# Appeal Decision

**Appeal Ref: APP/R5510/D/23/3332731**

**49 Queens Walk, Ruislip, Hillingdon, HA4 0LX**

- The appeal is made under section 78 of the Town and Country Planning Act 1990 against a refusal to grant planning permission.
- The appeal is made by Mr K Singh against the decision of the Council of the London Borough of Hillingdon.
- The application Ref 1055/APP/2023/1859, dated 26 June 2023, was refused by notice dated 18 August 2023.
- The development proposed is a ground floor rear and part first floor rear extension. 2 x rear dormers. Balcony with screens to roof of ground floor rear extension.

DRAWING TITLE:	
PROPOSED BLOCK PLAN, LOFT PLAN AND LOFT SECTION

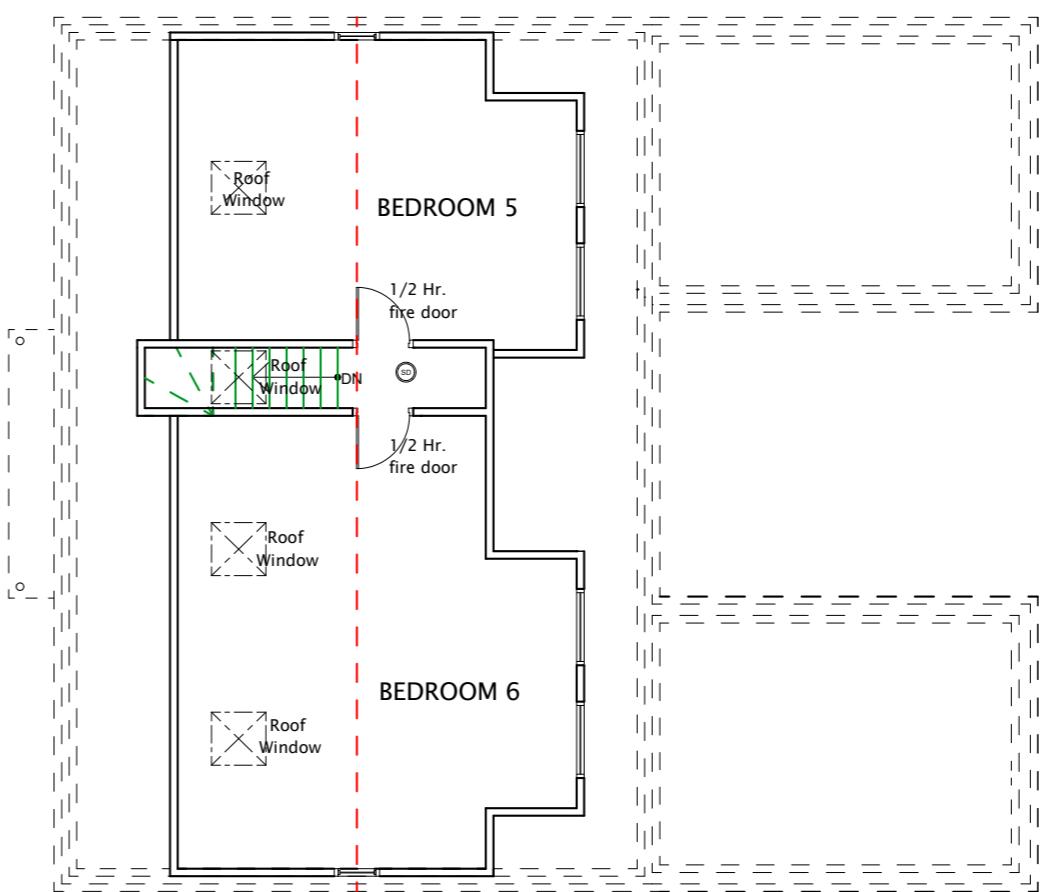
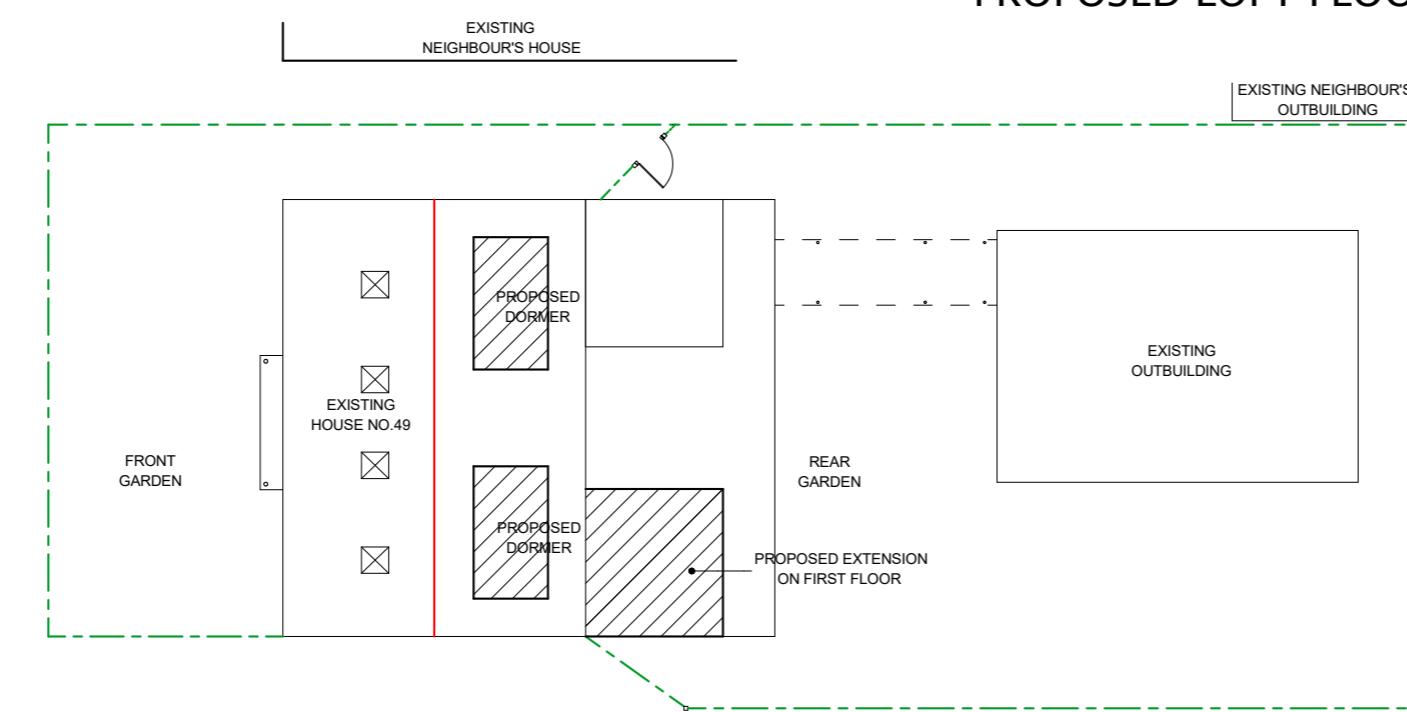
13. Further, this sense of incongruity would be increased as a result of the proposed balcony, which would appear conspicuous, drawing the eye and emphasising the visual dominance of the proposal.

14. In addition to all of the above, I find that the proposed dormers would add further bulk to what is already a large and dominant roof form. They would combine with the proposed rear extensions and balcony to result in a form of development that would overwhelm the appearance of and fail to appear subordinate to, the host dwelling.
